Necton Parish Council Boreas ExA Q2 Responses 17 February 2020

Q2.9.6.4 Substation Integration into Local Landscape

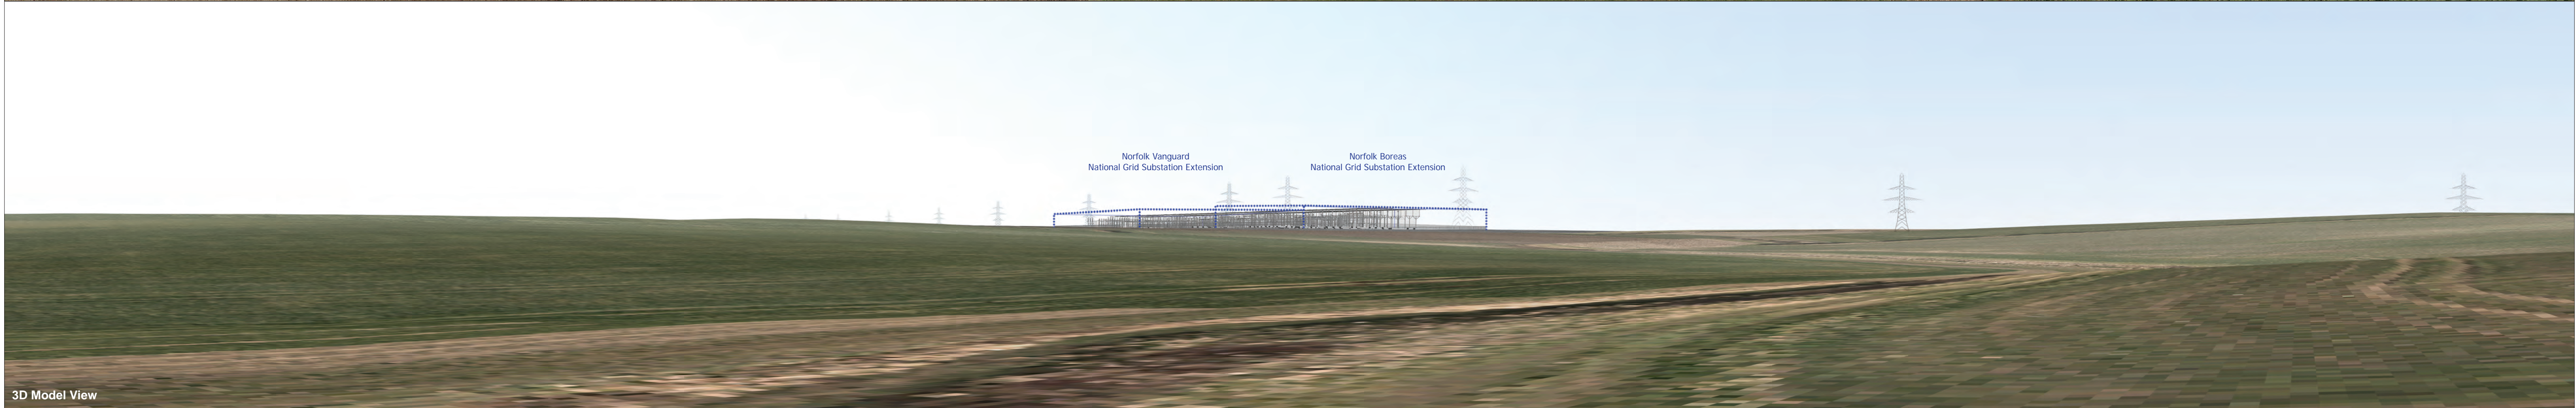
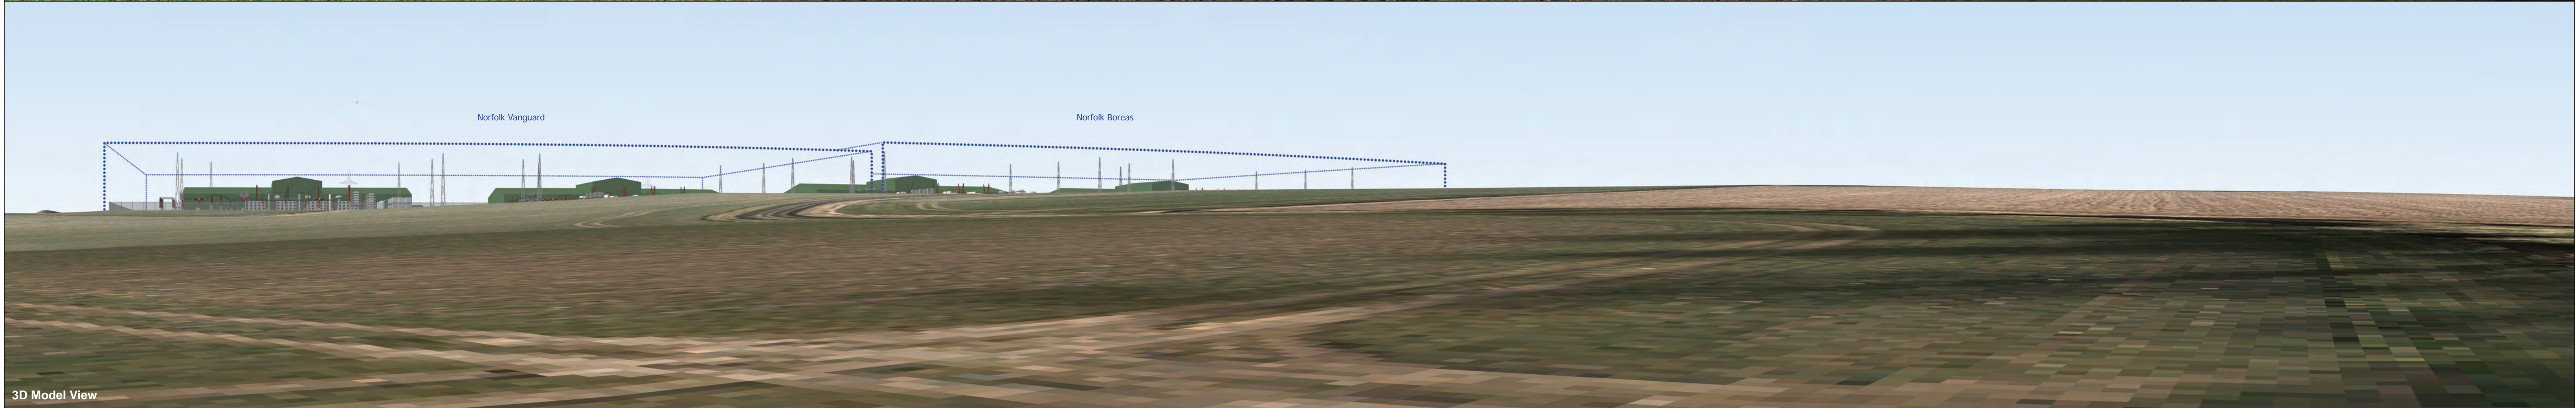
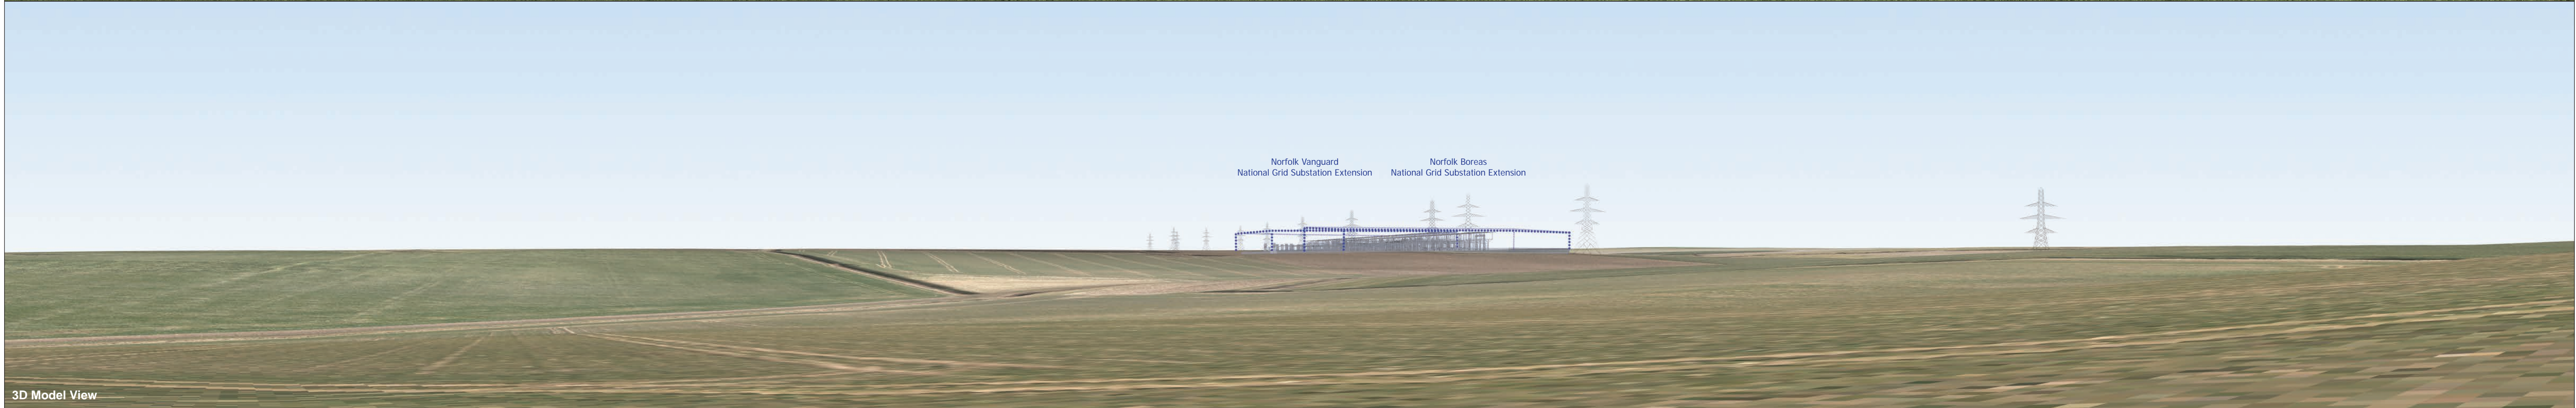
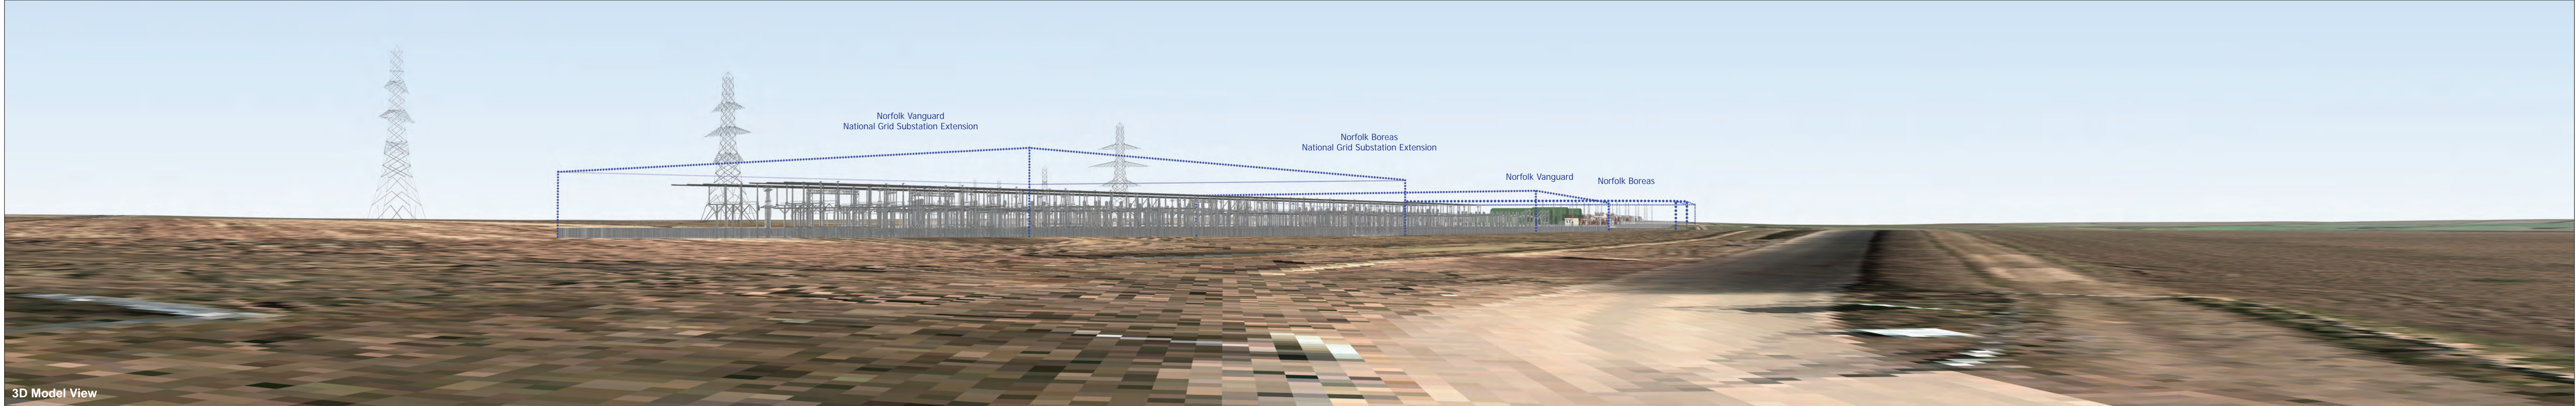
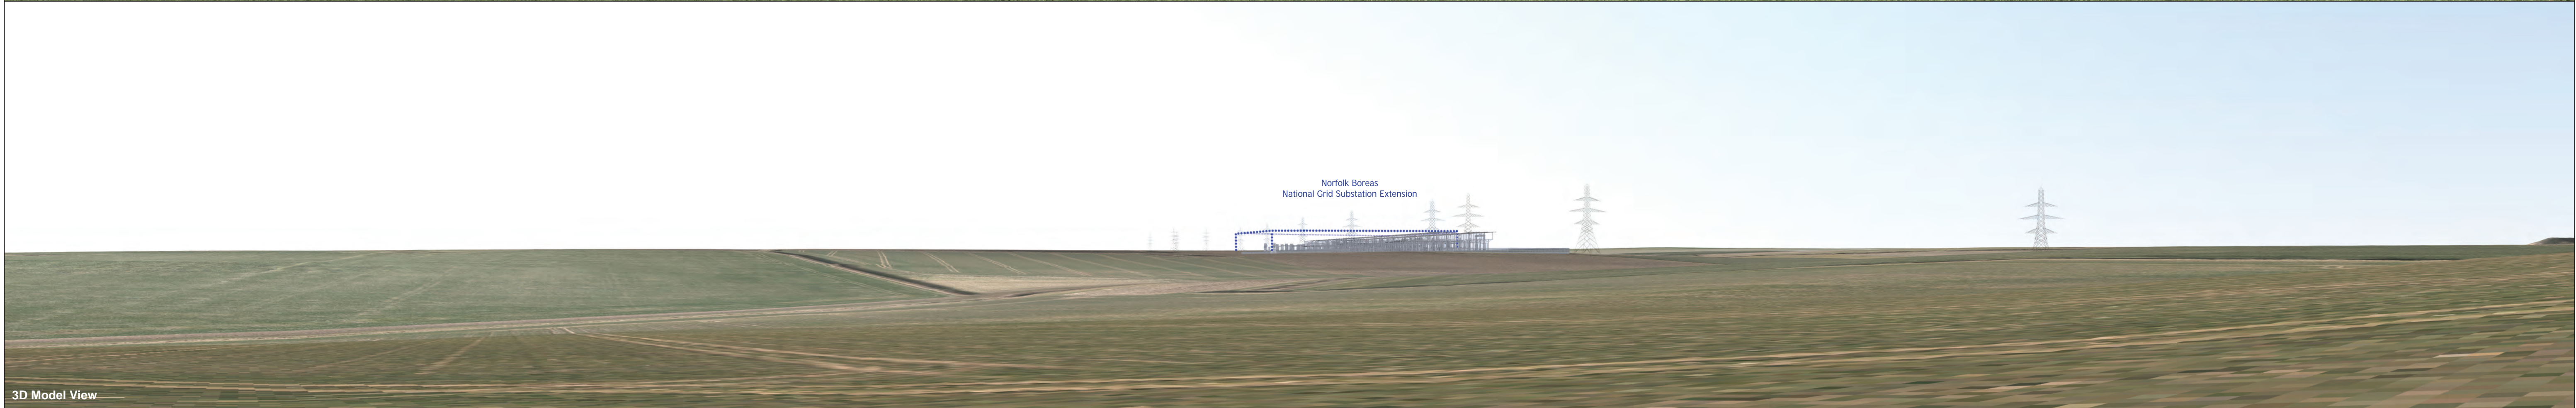
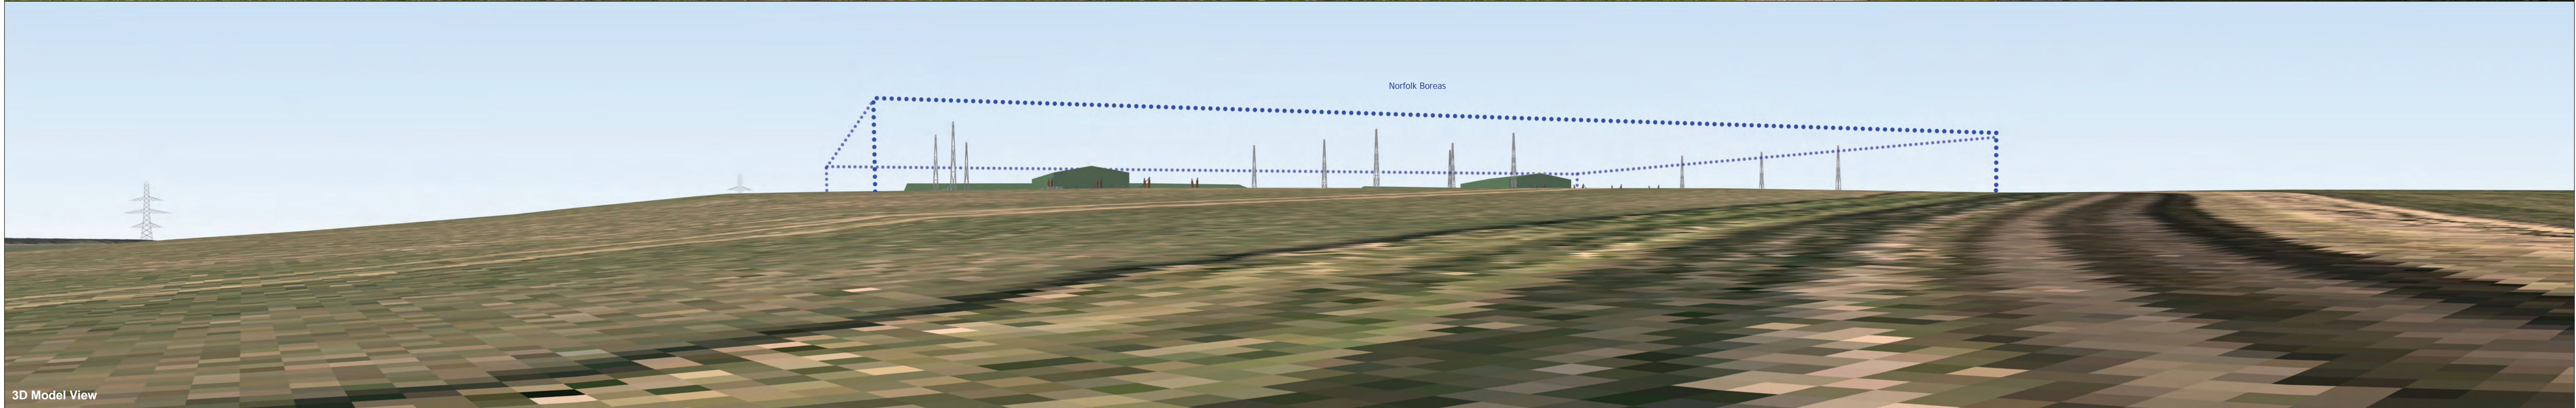
Necton Parish Council are concerned about the height of the converter halls with respect to their surroundings. We would like the following wording to be included in the DAS:

“The datum level for the converter halls will be set at the 65 metre contour line. All buildings higher than 13 metres above the datum should be sunk into the ground such that their height above the datum does not exceed 13 metres. Earth banks of 15 metres height should be placed around all exterior sides of the converter hall site (Vanguard and Boreas if both are built) which will hide the lightning conductor towers. Trees will be planted on the earth banks to stabilise them and provide additional screening.”

The Parish Council supports additional planting on earth banks between the converter hall area and both Ivy Todd and Necton villages. This should be a mandatory part of the design process.
